Longridge Town Council

1 May 2012

Application No.	Location
3/2012/0053 (Re-submission of 3/2011/0655P)	41 Dilworth Lane, Longridge, PR3 3ST
Planning Officer	Graeme Thorpe
Proposal	
Construction of three new two-storey terrace dwellings. Garden space allocated to each property. Six surface parking bays. Amended plans.	
Town Council Comments	
Councillors noted that the reference to "amended plans" appears to only relate to tree felling proposals for the whole site. In response to earlier consideration of this application Councillors expressed the view that there would be a loss of amenity if trees are felled. Councillors believe that as a result of an initiative in during the 1980's tree preservation orders were put in place to ensure the protection of these trees which now form a significant and highly valued landscape feature on entry to the town from the east. Councillors stress the importance of consultation with Mr David Hewitt, Countryside Officer, who was involved in securing preservation orders on these trees. Councillors do not express concern about the necessary removal of hedges if the application is approved. In September 2011, the Council expressed objection to this ap

Tre felling Plan Phase 1/2&3

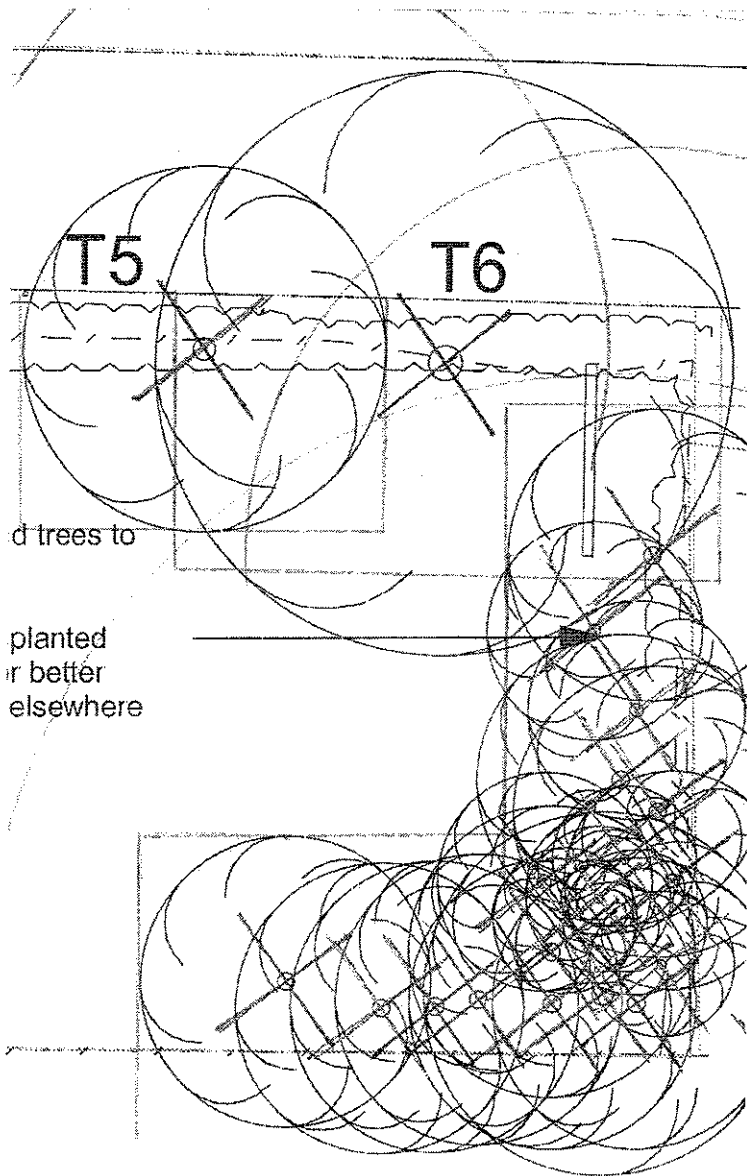
Application No.	Location
3/2012/0052 (Re-submission of 3/2011/0654P)	41 Dilworth Lane, Longridge, PR3 3ST
Planning Officer	Graeme Thorpe
Proposal	
Construction of a new detached triple garage with office space above. Amended plans.	
Town Council Comments	
Councillors noted that the reference to "amended plans" appears to only relate to tree felling proposals for the whole site. In response to earlier consideration of application 3/2012/0053 (3 two-storey terraced dwellings), Councillors expressed the view that there would be a loss of amenity if trees are felled. Councillors noted that the proposed tree felling plan is pertinent to the application to construct the detached triple garage and therefore express the same concern about the loss of amenity if trees are felled. Councillors believe that as a result of an initiative during the 1980's tree preservation orders were put in place to ensure the protection of these trees which now contribute to an avenue of trees on entry to the town from the east and as such are a very significant and highly valued landscape feature. Councillors stress the importance of consultation with Mr David Hewitt, Countryside Officer, who was involved in securing preservation orders on these trees. Councillors do not express concern about the necessary removal of hedges if the application is approved. The Council has previously expressed no objection to the construction of the garage providing that it is built with materials sympathetic to the character of existing properties in the area, and that it is only used as a private garage and office space; that position is unchanged. It was resolved however that the Council objects to the amendment now proposed i.e. the tree felling plan.
